Re: Taronga Zoo Sydney Wildlife Hospital (SSD-33211326)

I am writing in response to the exhibition of the Environmental Impact Statement for the development of the Taronga Zoo Wildlife Hospital. Council supports the provision of the wildlife hospital as facilities for the care and conservation of animals is in accordance with the core objectives of the Zoo.

Image 23: Landscape Plan [Eximia Design] L-DA-11

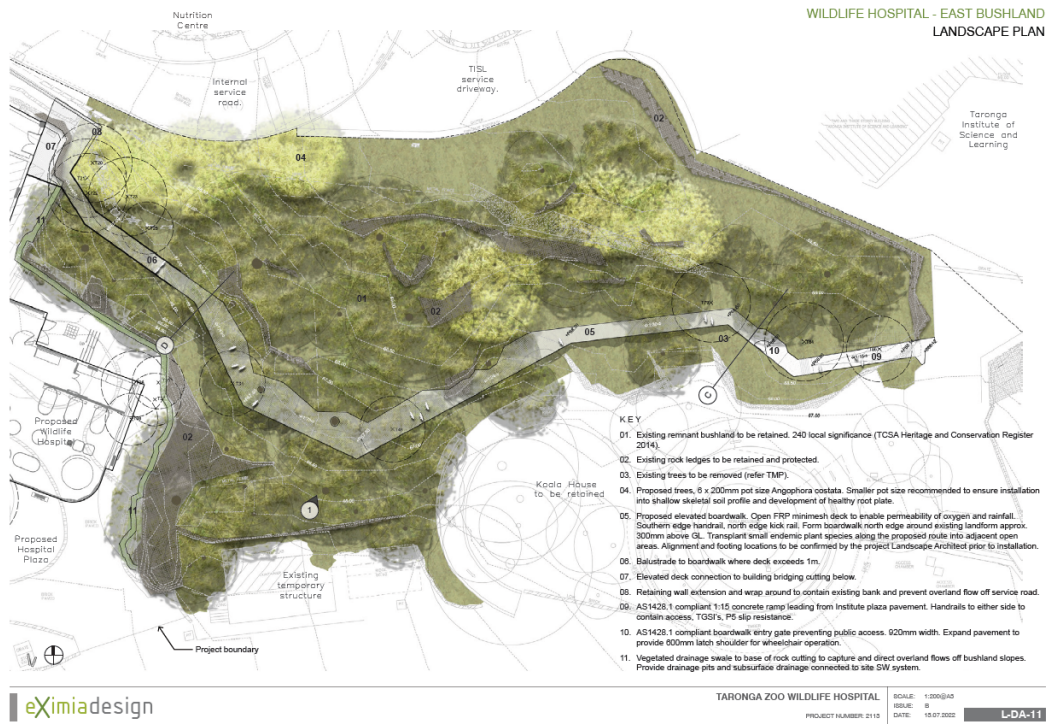
Further, to offset the required tree removal, the development should provide for a net increase in the total number of trees over the whole site. This should include suitable local indigenous large canopy trees sited below the new building so as to maintain the dominance of vegetation over built elements.
